Application No: AW/214/20/HH
Site Address: 15 Fernhurst Gardens Aldwick PO21 4BA
Description of works: Proposed side extension and dormer enlargement.

Thank you for your internet representation made on 10th October 2020 which has been recorded as an objection with the comments as follows:

Proposed Dormer Enlargement & Side Extension
Plans and Elevations
Planning
Date
August 2020
Scale
1:50

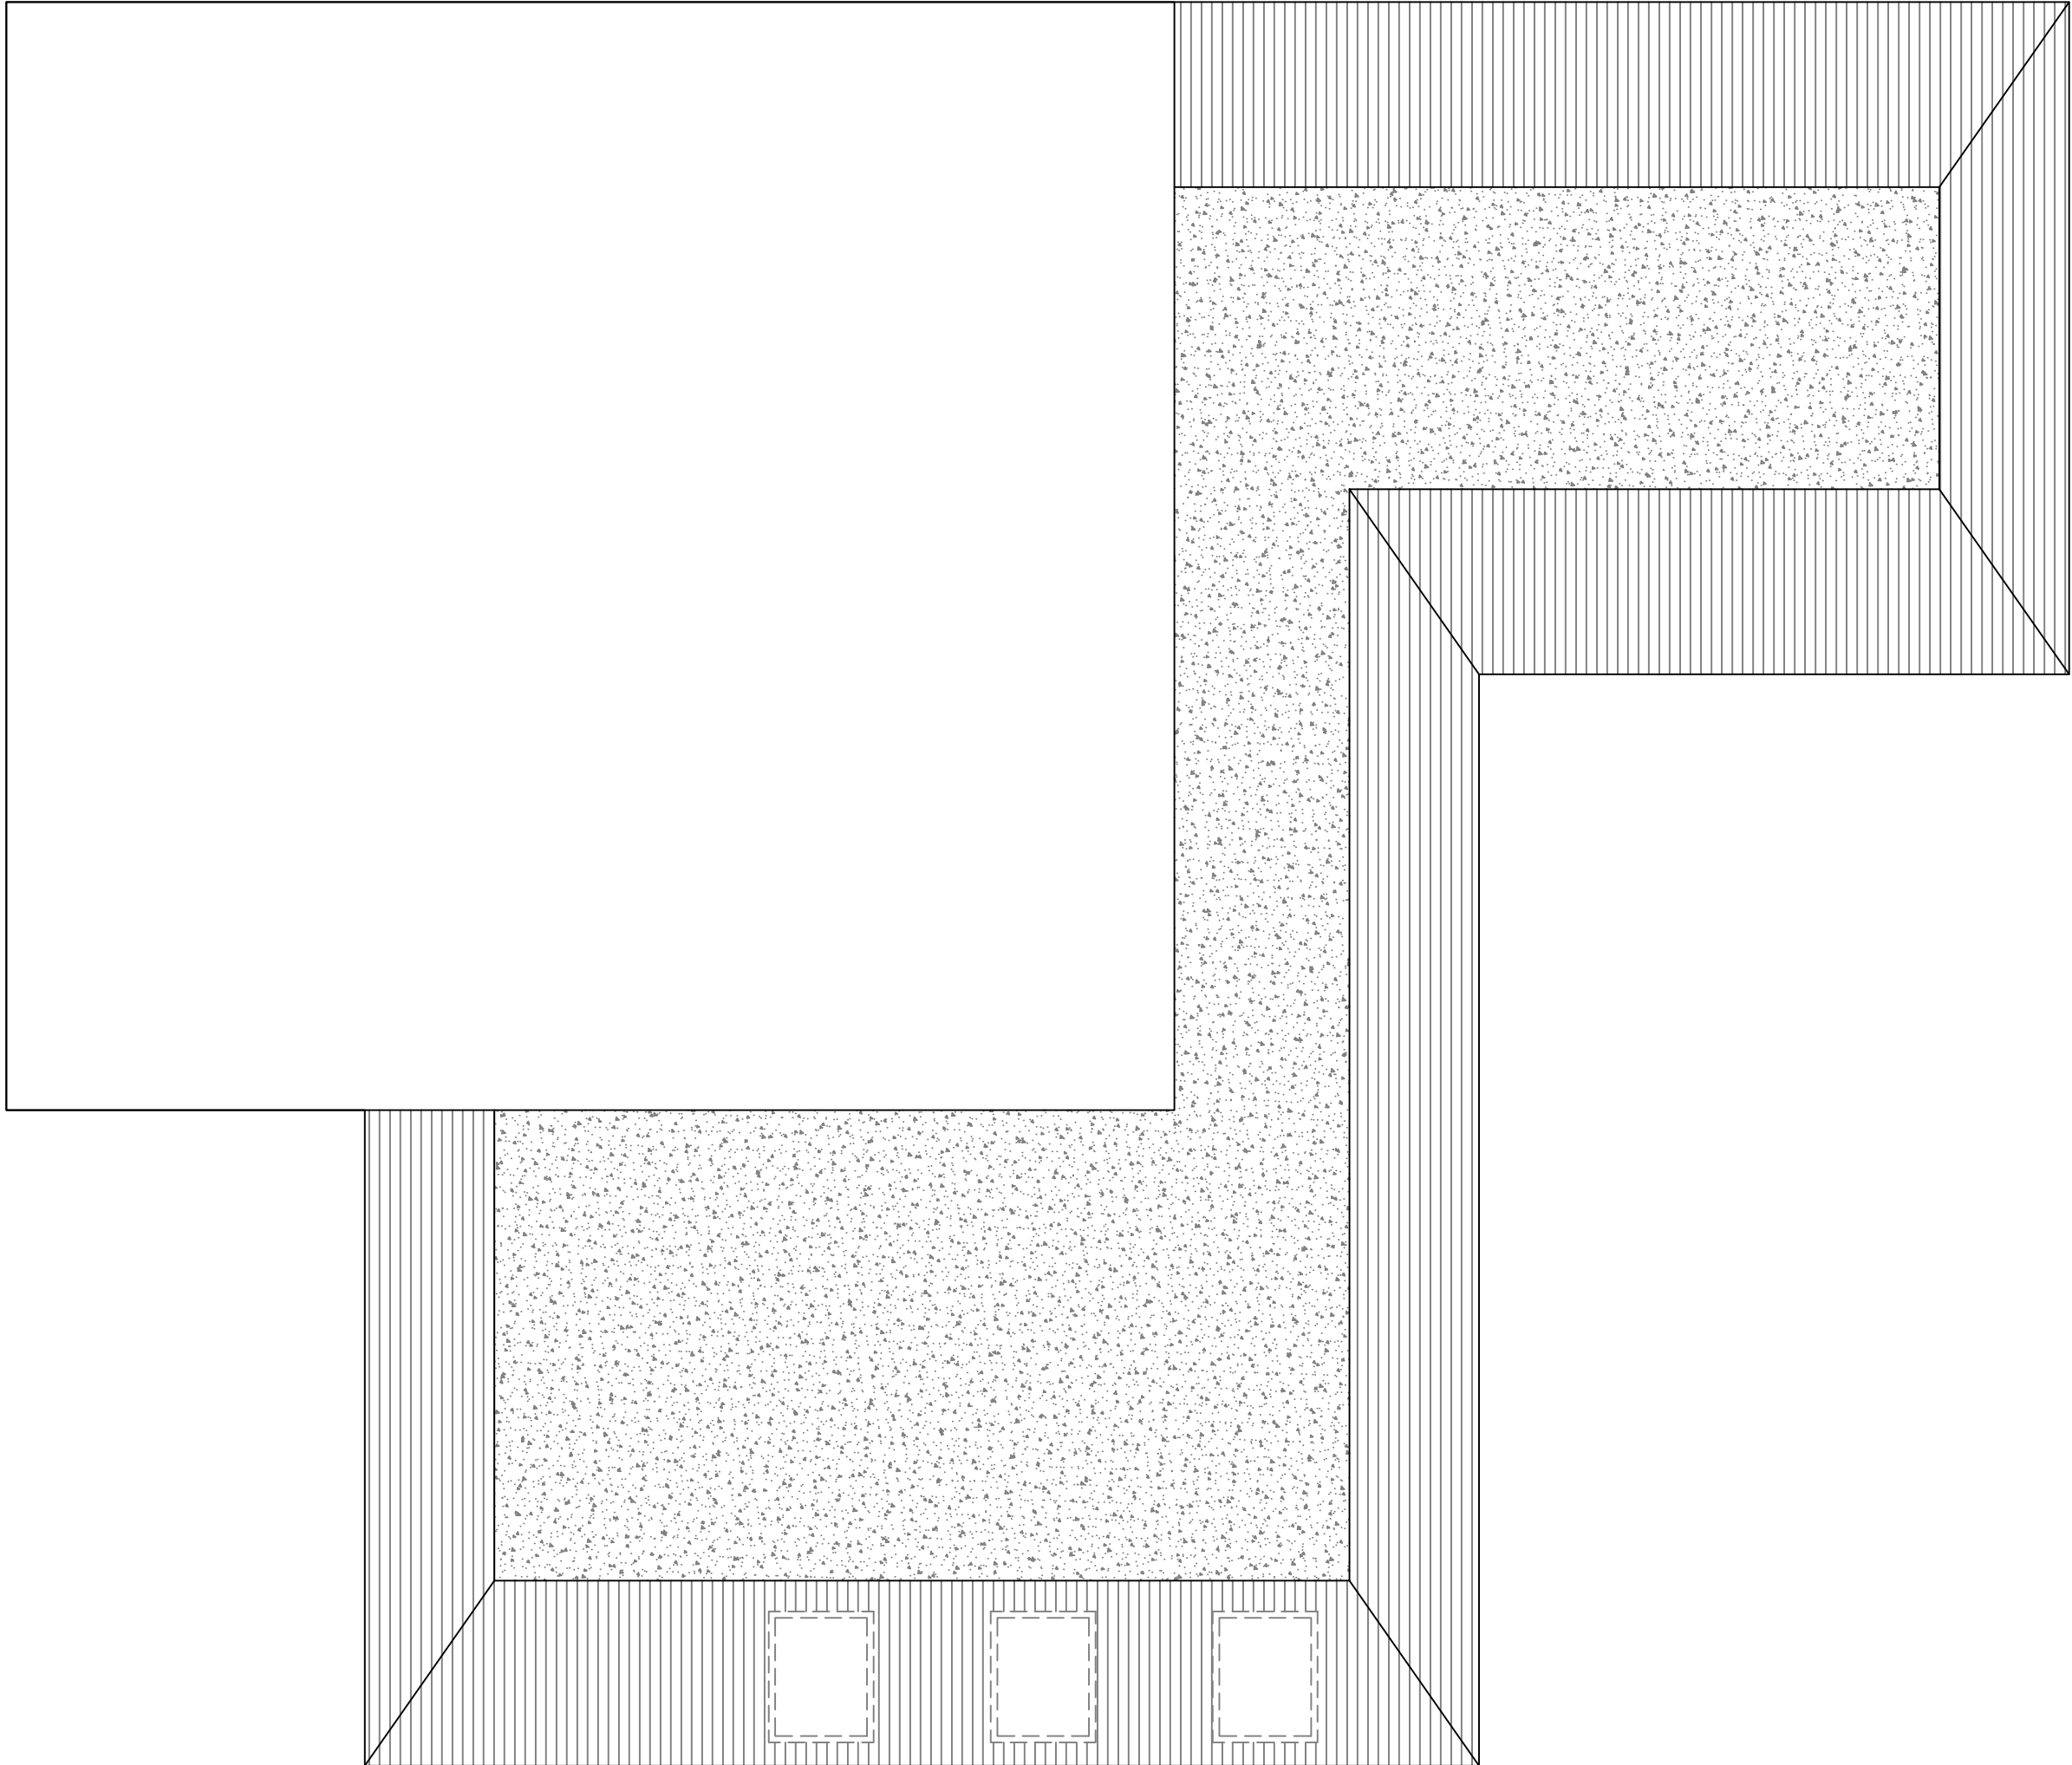
As owner of 17 Fernhurst Gardens I am concerned about parking and my access to shared drive- incidentally not shown on the block drawing correctly. The pebbled driveway in a T shape is shared between the two properties for access to the historic and current garages. With the extension access to these garages at 15 will be compromised I believe and if a car is parked on shared driveway area in front of the side extension at 15 it may block my access. Historically everyone backs out of 15 and 17 garages and turns in the other side of the T to get out of the shared drive onto Fernhurst Gardens. I realise this comment is after deadline for comments but did not see the application on the lamppost till I was at the property recently. It would have been nice to have been mailed the application.
